Re: Capstone Student Housing Zone 3
3003 Transport SE
Request for Permanent C.O. –Accepted
Engineer's Stamp dated: 12-13-13, (M15D026)
Certification dated: 8-13-14

Re: Zone 3 Grading Plan, Engineer's Stamp Date 12-03-2013
Zone 4 Grading Plan, Engineer's Stamp Date 12-13-2013 (M-15/D026)

Re: Capstone Student Housing Zone 4
3003 Transport SE
Request for Permanent C.O. –Accepted with Conditions
Engineer's Stamp dated: 12-13-13, (M15D026)
Certification dated: 8-14-14

**ZONE 4  
DETAILED GRADING PLAN**

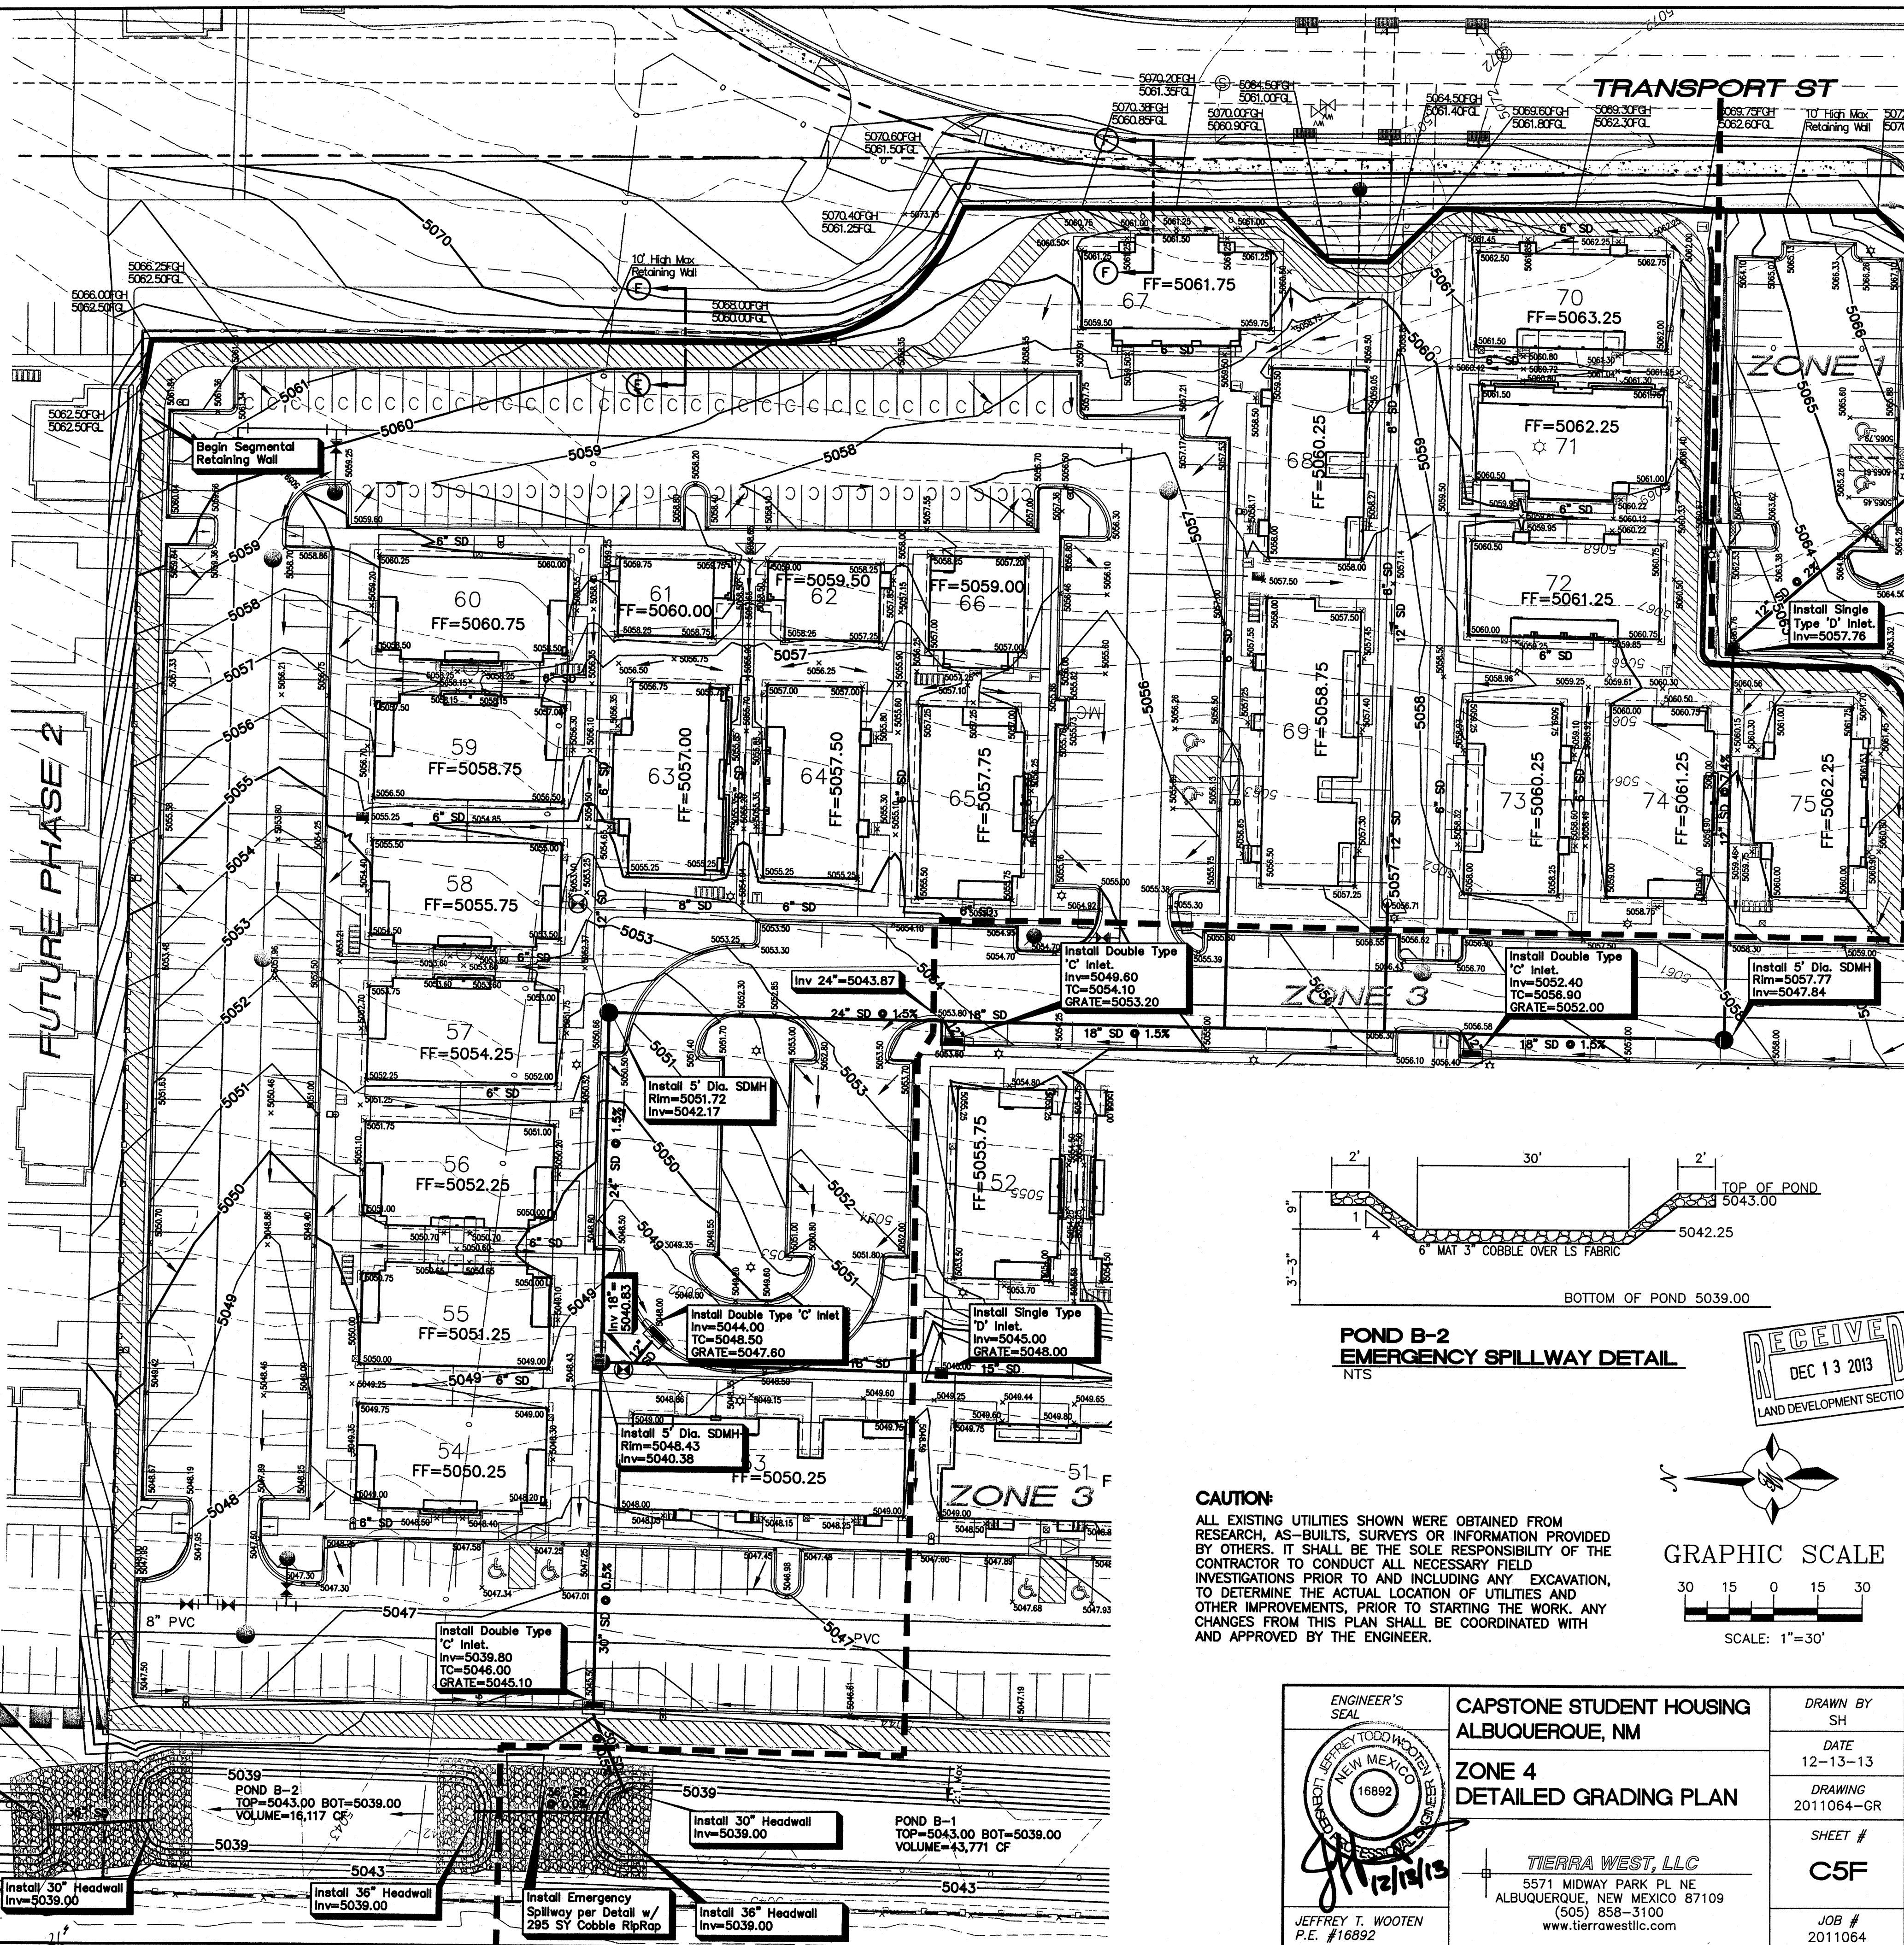
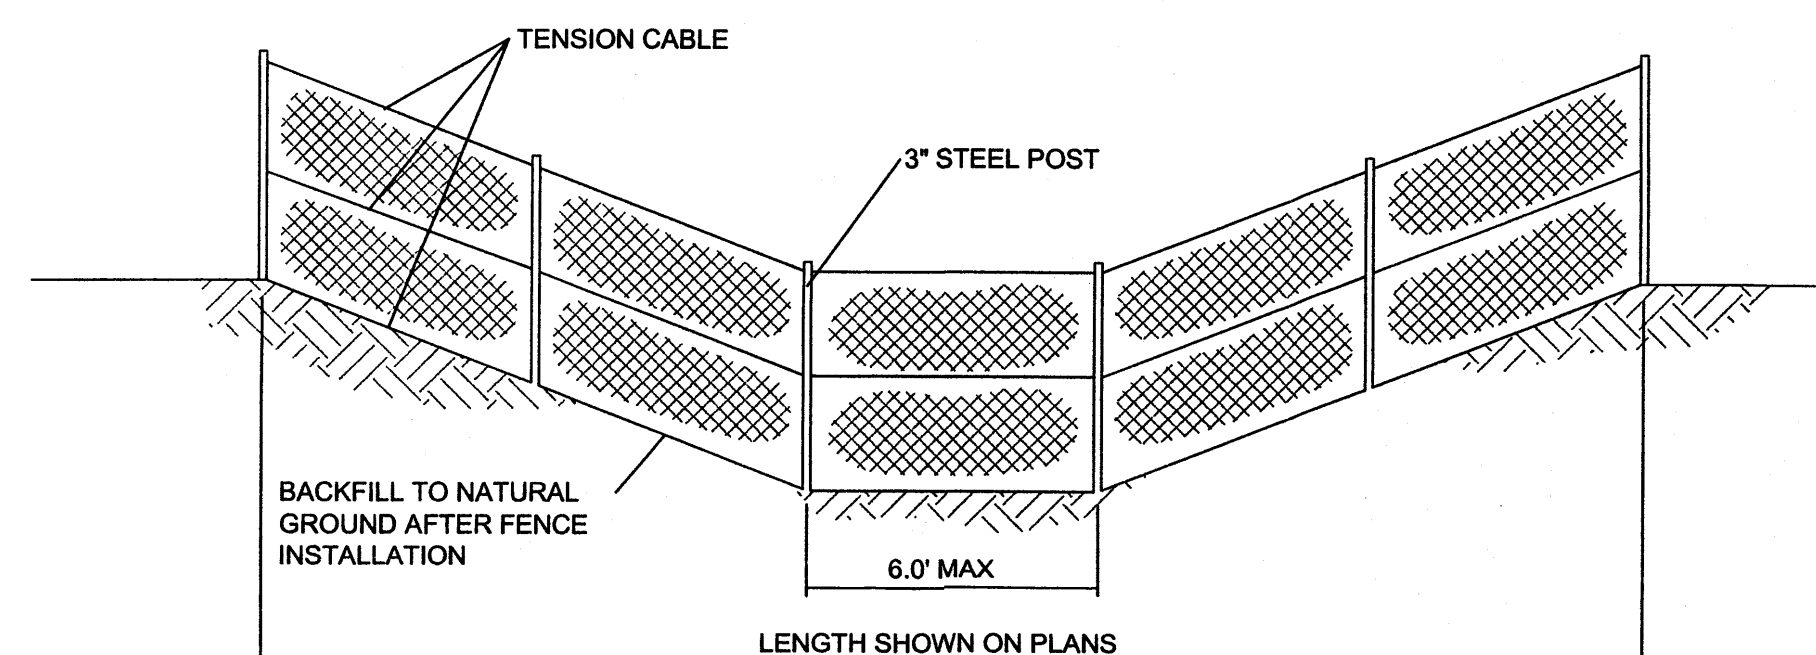
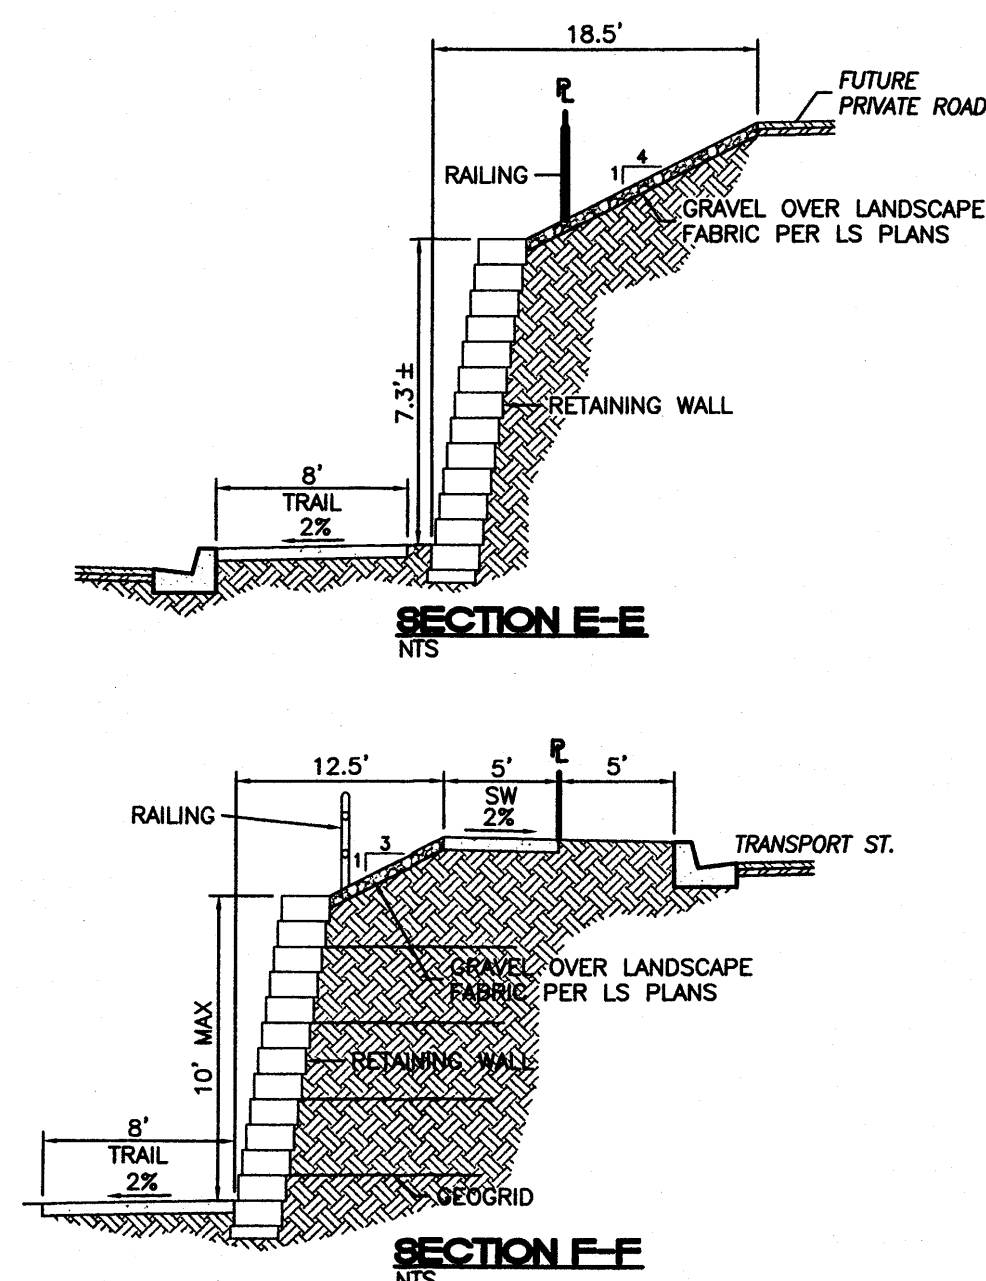
- 30" headerwall should be change to 36" headerwall for the 36" storm drain pipe connecting Pond B-2 to Pond B-3.
- When providing as-built drawings, please provide all inlet numbers, inlet/mh/storm drain pipe inverts, inlet top of curb and grate elevations, and all the storm drain pipes slopes and normal flow depths.
- As-built pond volumes should be provided.

1. The manhole connections to the public storm drain must be confirmed to be acceptable.
2. As-built grades are required per the DPM.
3. How does Pond B-2 function as designed when it was built at 85% of its design capacity? It seems the grading should be revised.
4. Install the trash screen at the outlet to Pond B-3.
